30 September 2020
Our Ref: 9809A.15PS_s4.55(1A)_Mod 2

**RE: SECTION 4.55(1A) APPLICATION TO MODIFY SSD 8365 (MOD 2)
PENSURST PUBLIC SCHOOL
510 FOREST ROAD, PENSURST**

LANDSCAPE SITE PLAN
GROUND LEVEL SOUTH

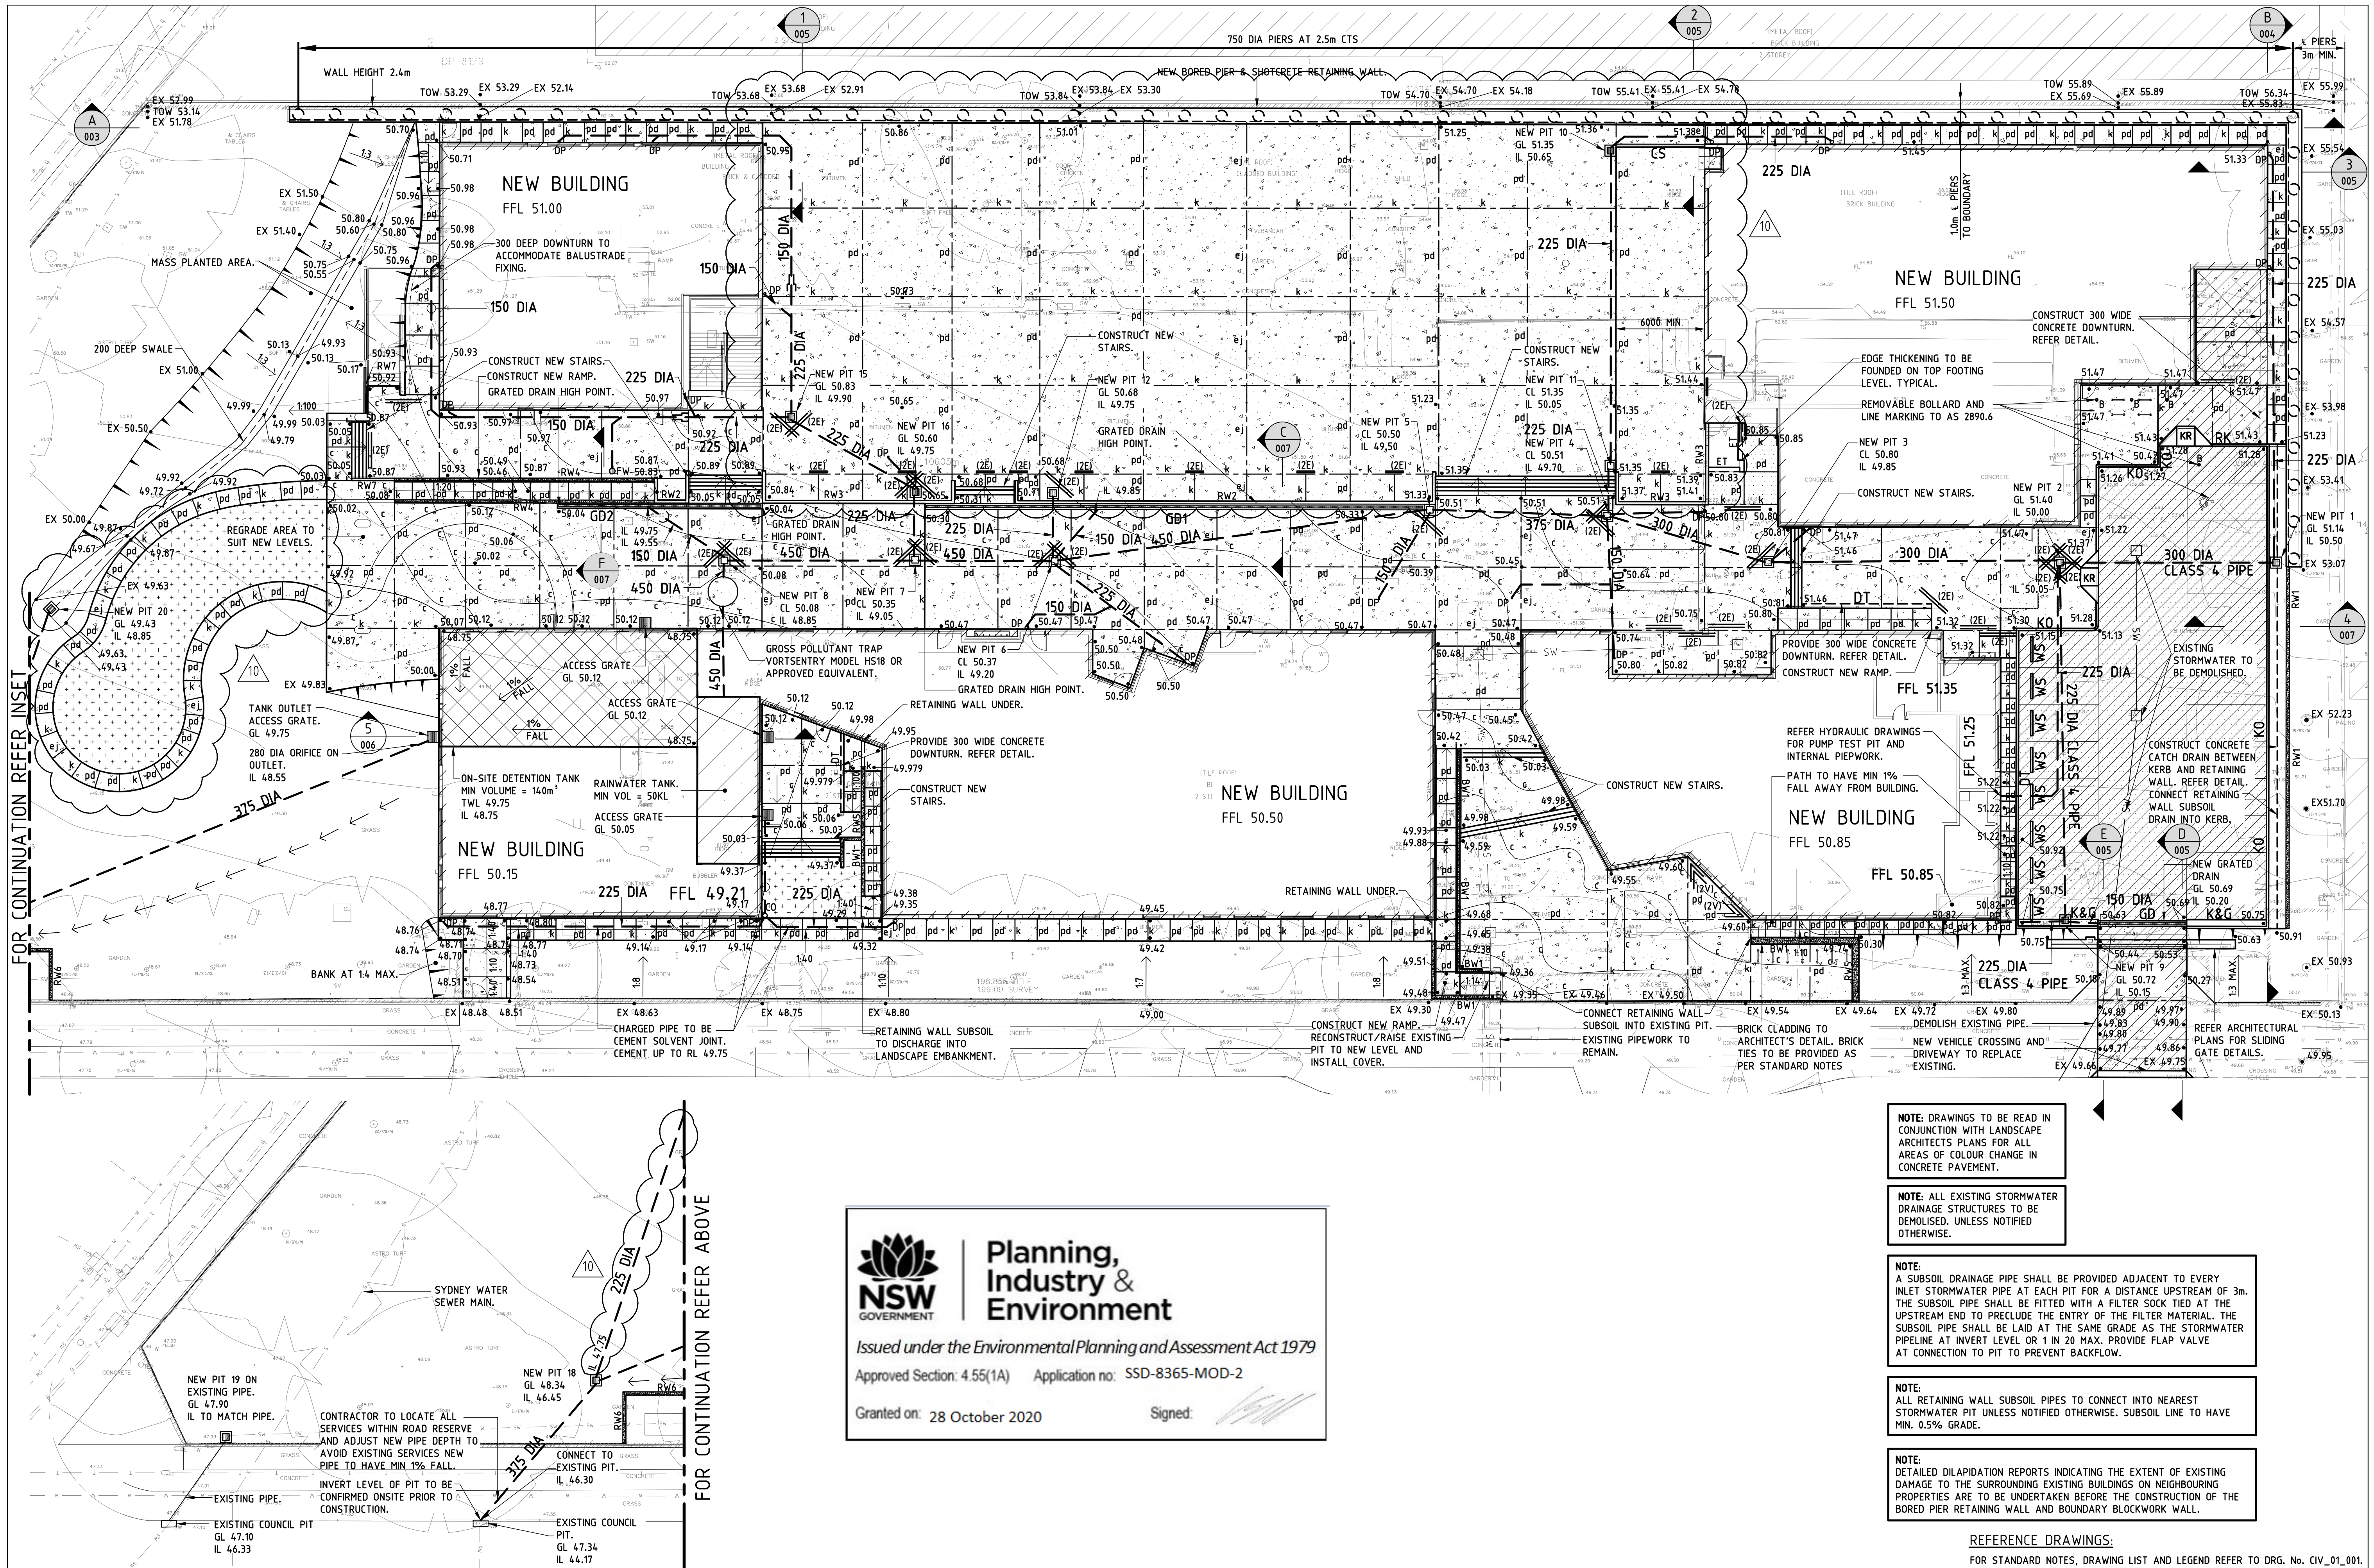
- Increase turfed area, decrease astro turf and re-align pathway and drainage (see **Dark Blue** mark up in **Figure 2**);
- Amend planting locations for ten (10) Crepe Myrtle (*Lagerstroemia* 'Natchez') trees (see **Orange** mark up in **Figure 2**) with no change to total number of plantings;
- Change tree species along boundary to Lilly Pilly (*Acmena smithii* 'Redhead') in order to limit crown spread and reduce overhanging branches over boundary (pursuant to discussions and agreement with neighbours) (see **Light Blue** mark up in **Figure 2**);
- Install new double gate to allow access for Fire Brigade (see location identified in **Pink** in **Figure 2**); and
- Extend brickwork to roof line on northern façade (see **Red** bubble in **Figure 3**).

The minor landscaping amendments at the southern end of the site require minor adjustments to footpath, swale and stormwater pit connections. These are reflected in the updated plans, and will not give rise to any adverse impacts.
